## **OXFORDSHIRE COUNTY COUNCIL'S RESPONSE TO CONSULTATION ON THE FOLLOWING DEVELOPMENT PROPOSAL**

**Application no:** 16/02586/OUT

**Proposal:** Phase 1 of the proposed new business park ("Bicester Gateway") comprising up to 14,972 sq m (Gross External Area) of B1 employment based buildings, plus a hotel (up to 149 bedrooms), with associated infrastructure, car parking and marketing boards.

## **Transport**

EXISTING WALKING PROVISION

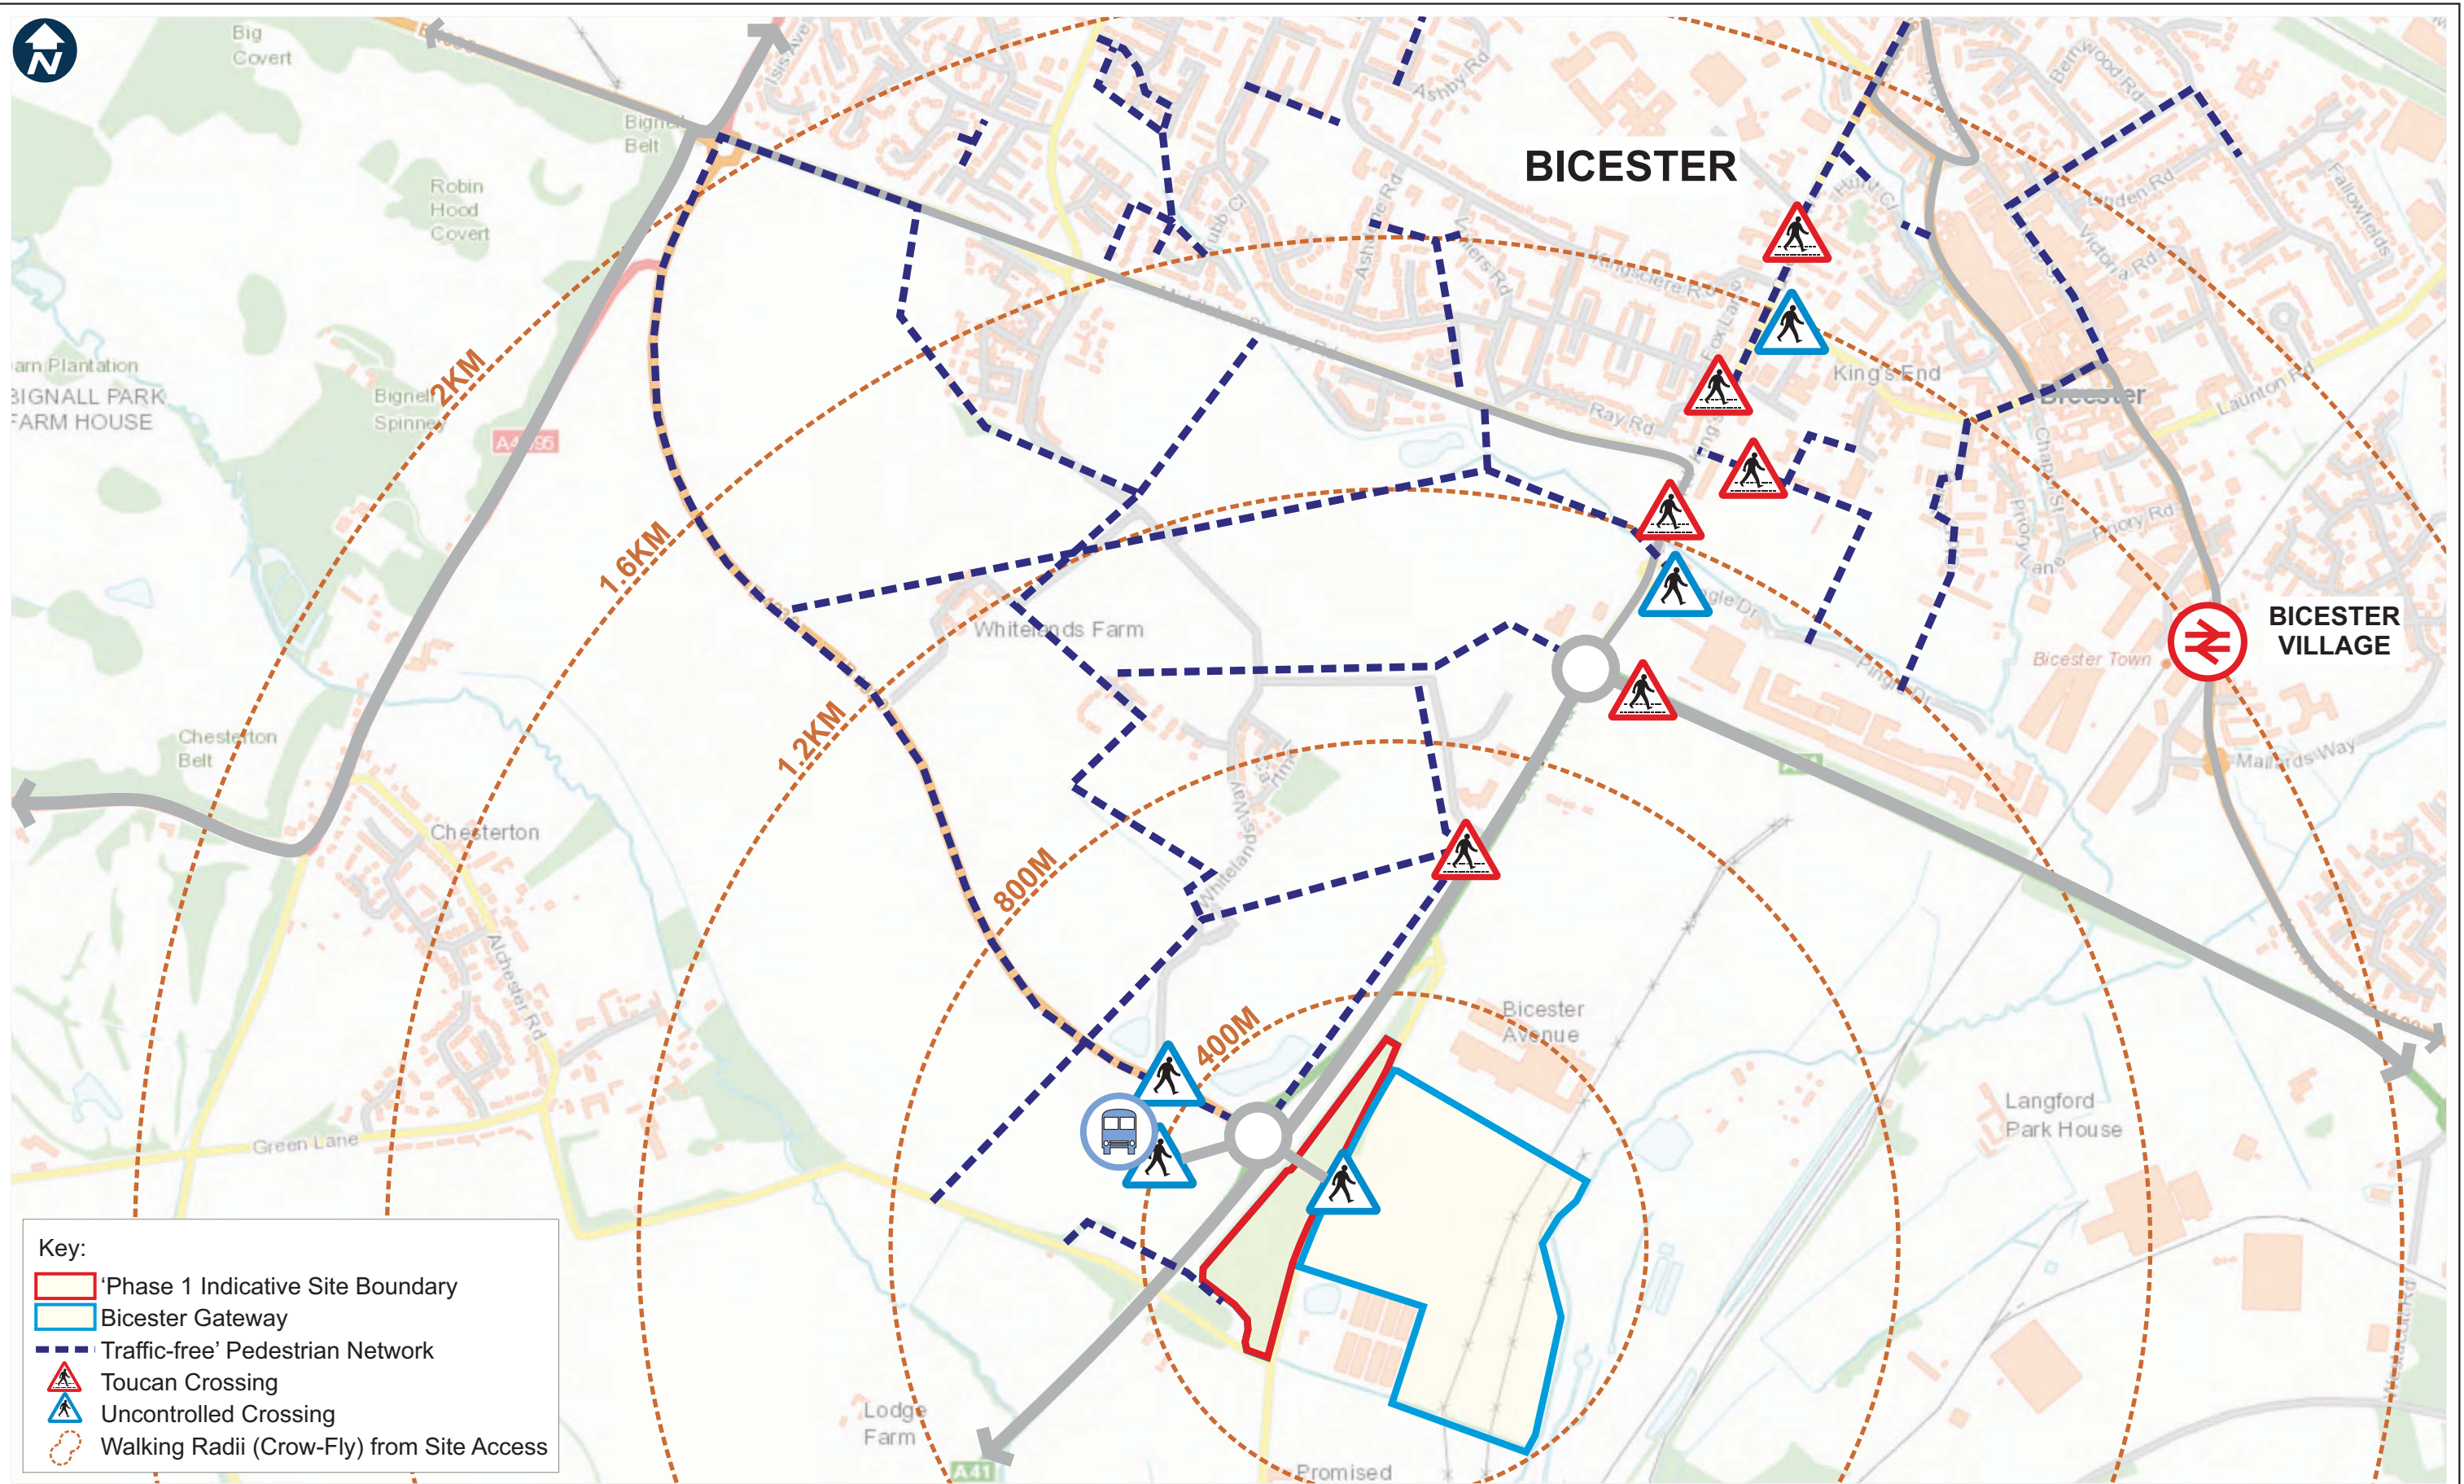
There is an existing shared use footway/cycleway along Wendlebury Road from the junction with the Vendee Drive Link road to a point opposite the sewage works entrance next to Bicester Avenue Garden Centre. No additional footway along Wendlebury Road is proposed. It is proposed that pedestrian/cycle access would be taken from a new 3m wide shared use track alongside the A41. However, the drawing shows no actual access points into the site (neither does the masterplan) – this needs to be confirmed and secured.

In my opinion a footway along Wendlebury Road should be provided too as this will be a preferable route for many, away from the noise and traffic of the A41. It is also necessary to cater for movements between the hotel and employment and the shops/café at Bicester Avenue – pedestrians would not take the detour to walk via the A41 and would likely walk in the carriageway of Wendlebury Road, which would not be considered safe. As the link road will become more busy, an improved crossing point needs to be provided, for both routes. This footway will also provide infrastructure that will definitely be required for the wider Bicester 10 development.
